PROPOSED AMENDMENT TO
WARRANT FOR
MR AND MRS N. BROADHURST
4 ST ANDREWS DRIVE
LAW
ML8 5GB

P :: PROPOSED SECTION
11 scale: 1:50

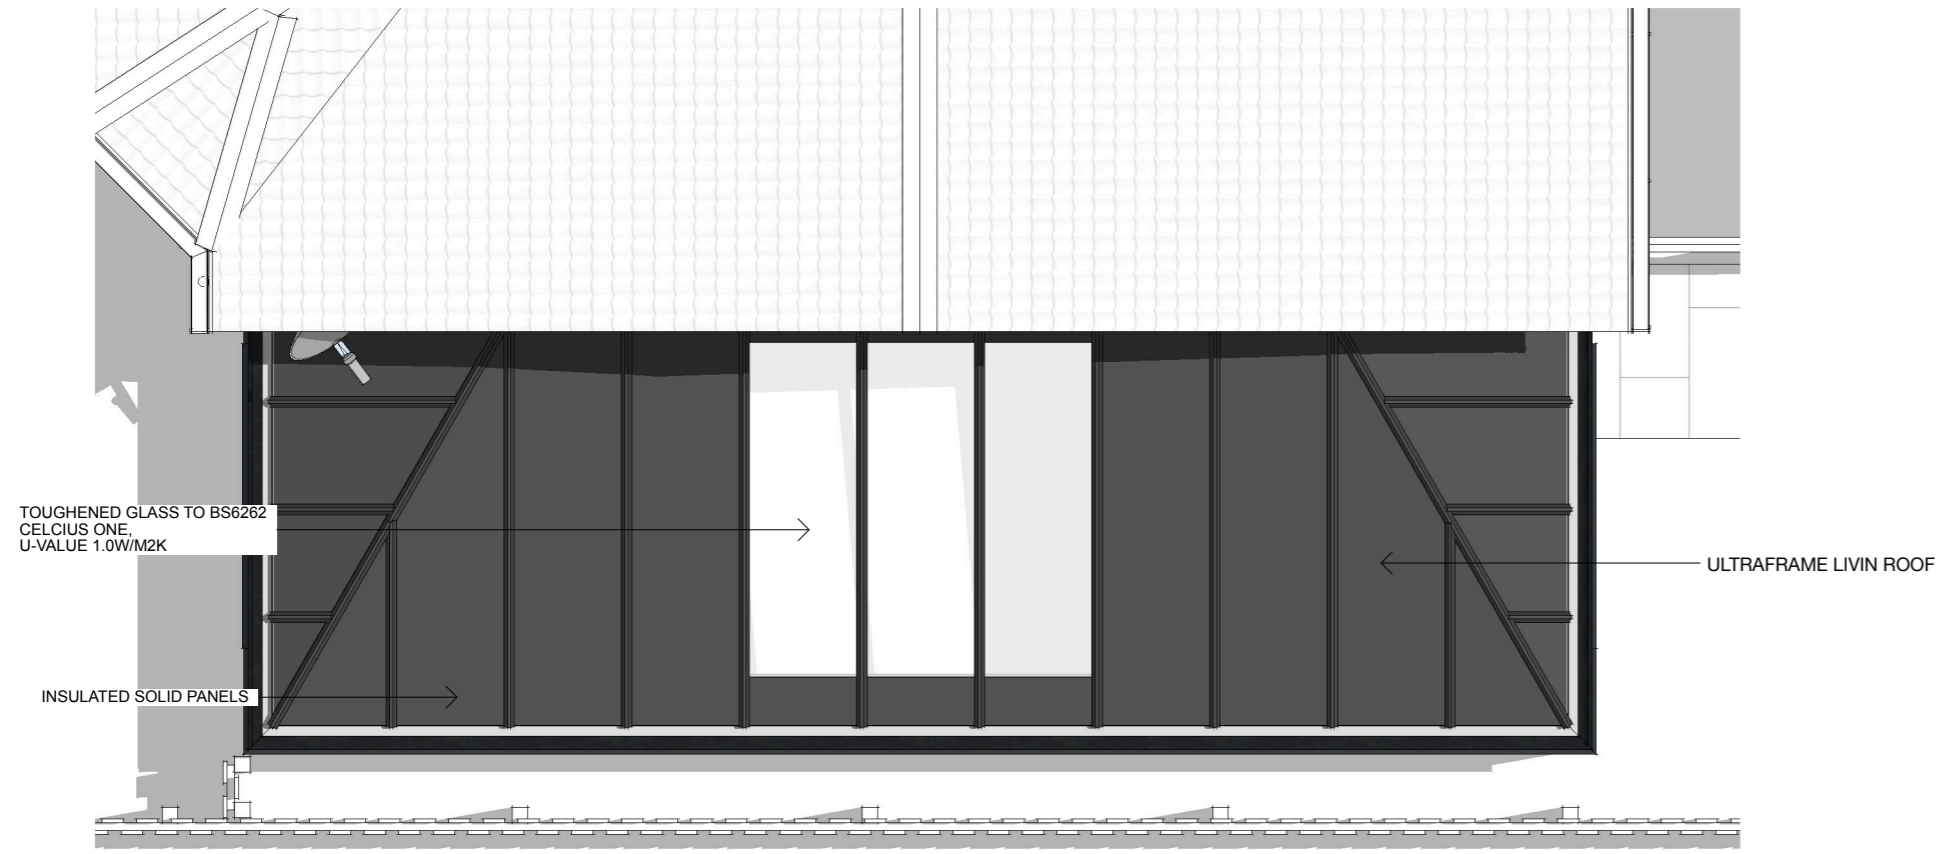
revisions:
door to front elevation of extension replaced with window, additional glass installed to roof, opening between extension and kitchen relocated to extension to lounge. wall insulation altered
